Our Ref: 171116
Your Ref: 6/2019/0857/MAJ
15 May 2019

Re: Splashlands Development, Stanborough Park

- Drawing No. 171116-CON-X-00-DR-C-1000; Rev. T2;
Drainage Strategy
- Drawing No. 171116-CON-X-00-DR-C-1010; Rev. P1;
Catchment Plan
- Calculations 171116-SW-1.3

Drawing Status
PRELIMINARY
Project
**STANBOROUGH PARK
SPLASHLANDS**
Title
CATCHMENT PLAN
Drawing No
171116-CON-X-00-DR-C-1010

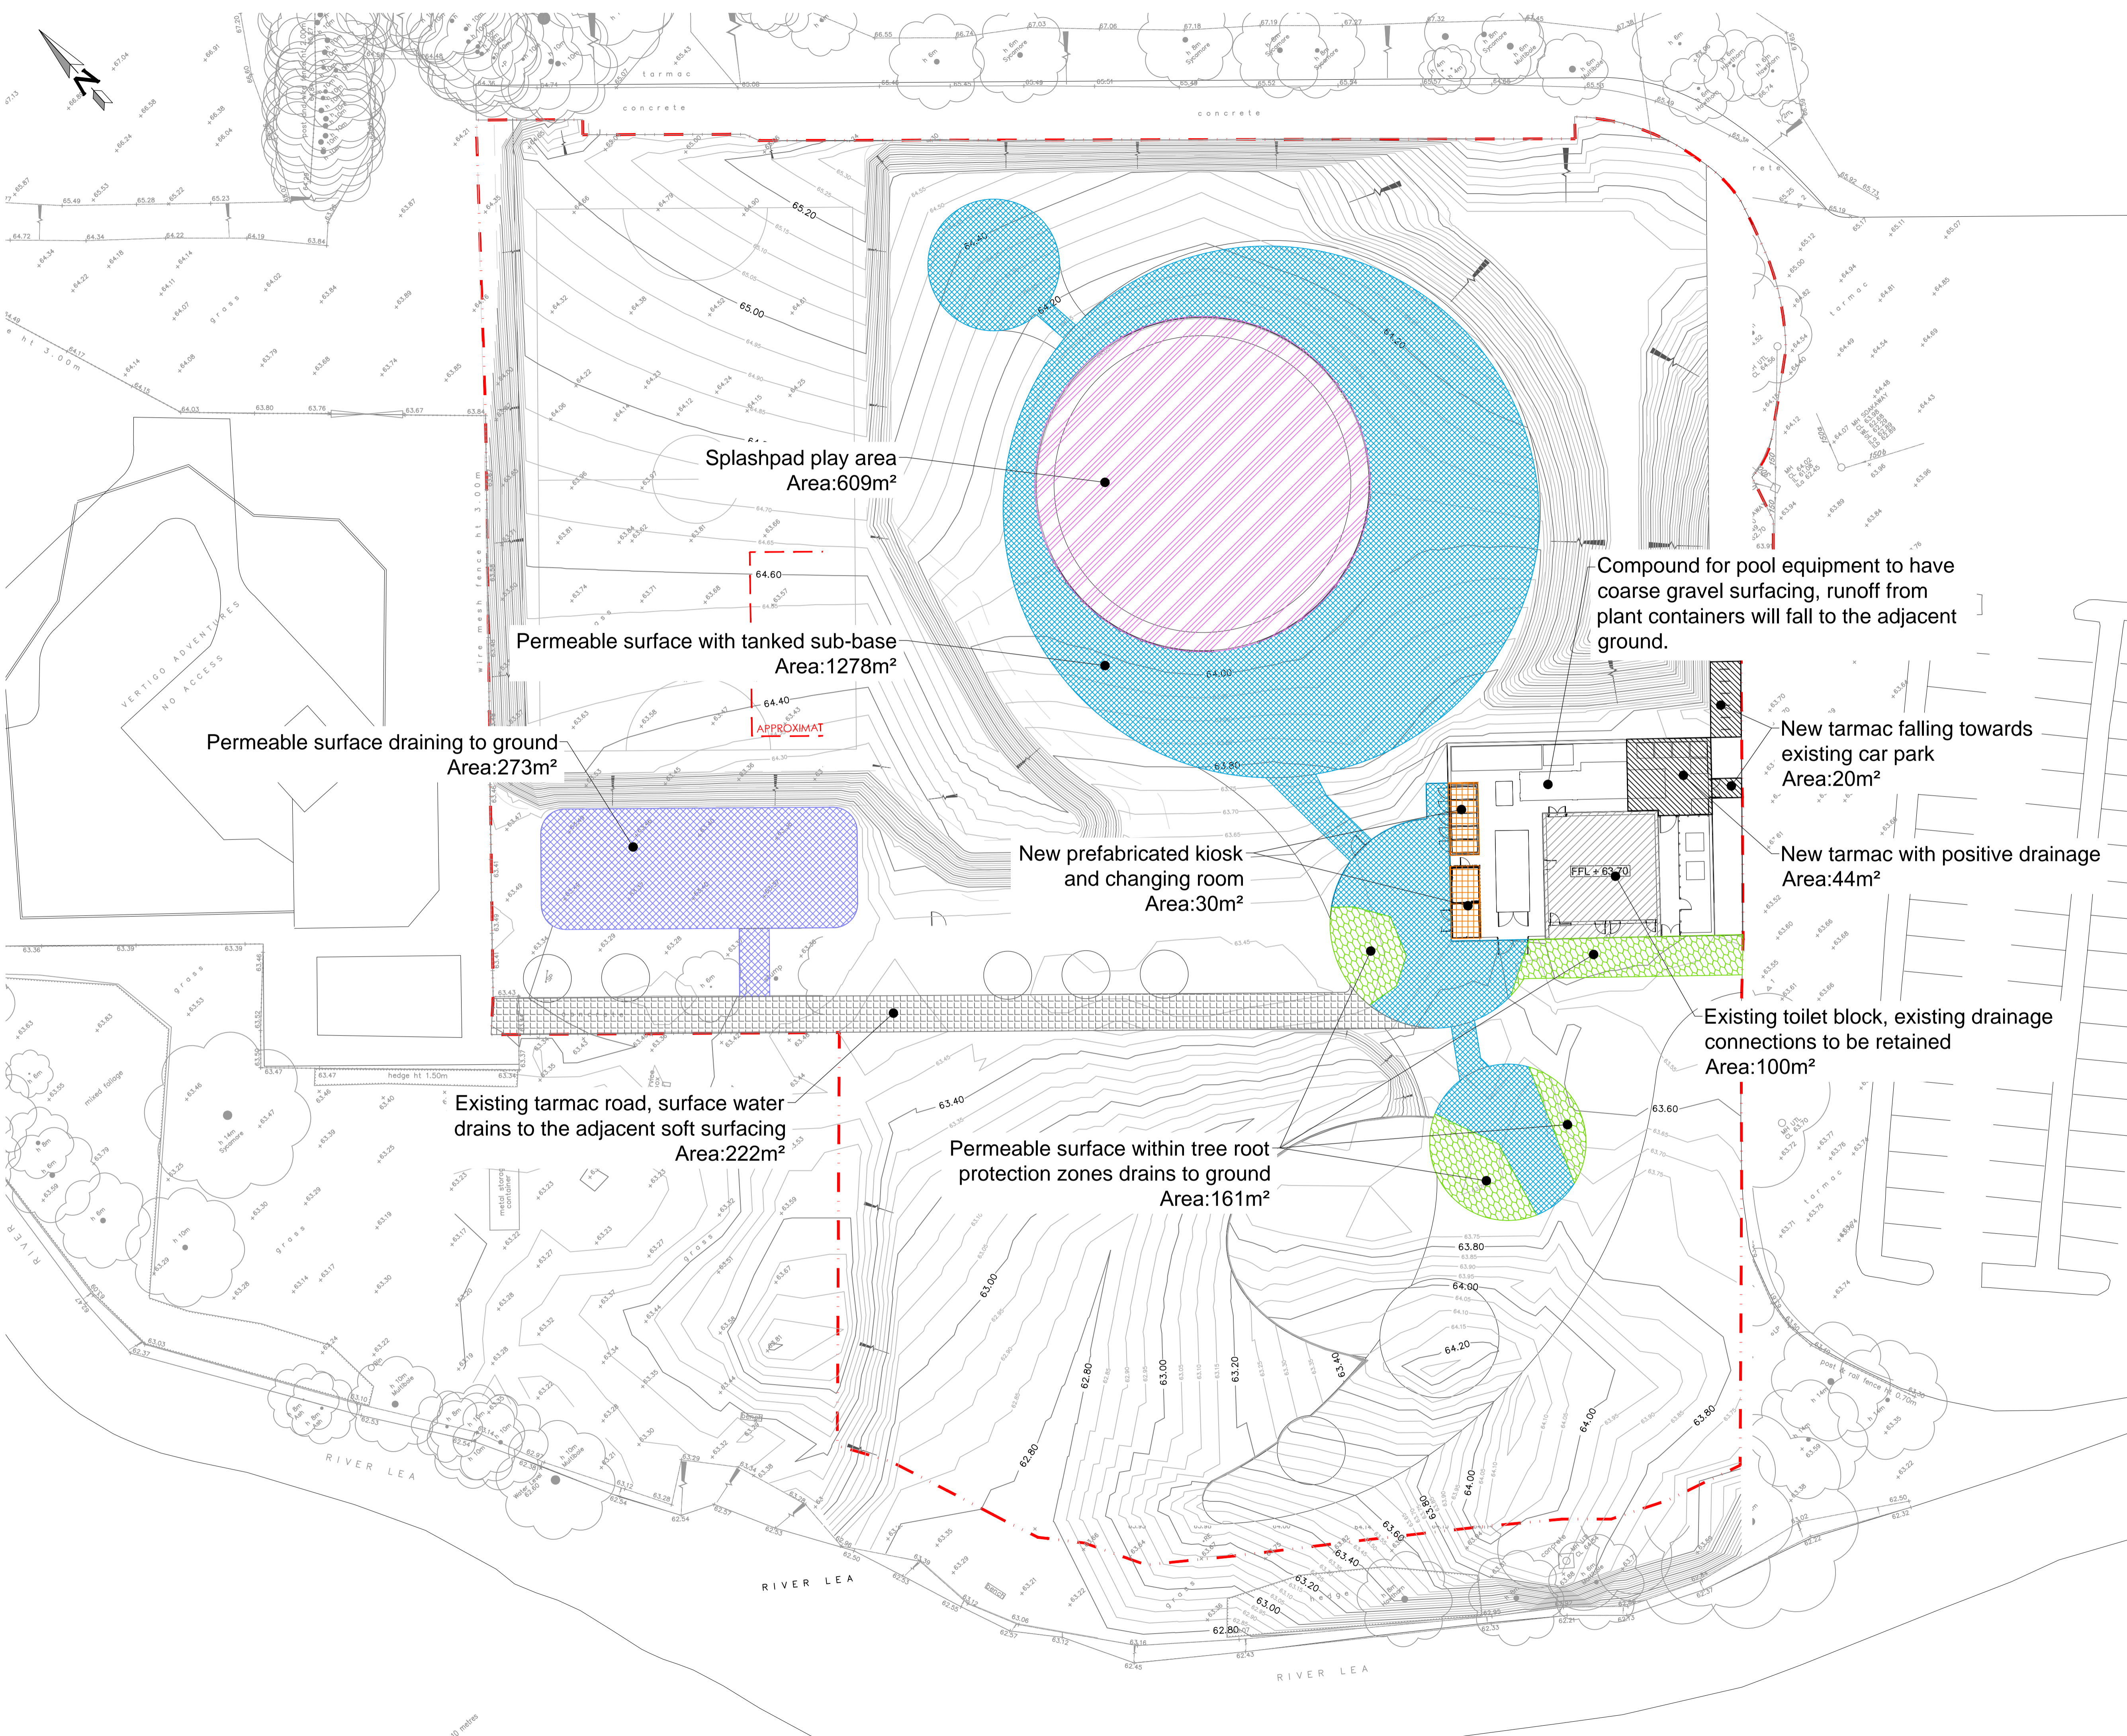
Extent of Impermeable Area

A catchment plan has been prepared to provide a reference for how the water from the redeveloped site will be managed. The different strategies are as follows:

- The retained toilet block will continue to use the existing drainage which will not be modified by the redevelopment.
- The majority of the new play area and surfacing will be tanked and discharge to a new headwall. The enclosed calculations demonstrate how this system will operate.
- The existing asphalt track across the site will be retained, surface water will be shed off the track to the adjacent soft landscaping; this mimics the current situation.
- The outdoor gym near the north-western edge of the site will consist of a permeable surface with an un-tanked sub-base. This will mimic the flow patterns from this area if it had remained an undeveloped (grassed) area. It is not feasible to install a drainage network from this location as there is insufficient depth to make a connection to the site outfall.
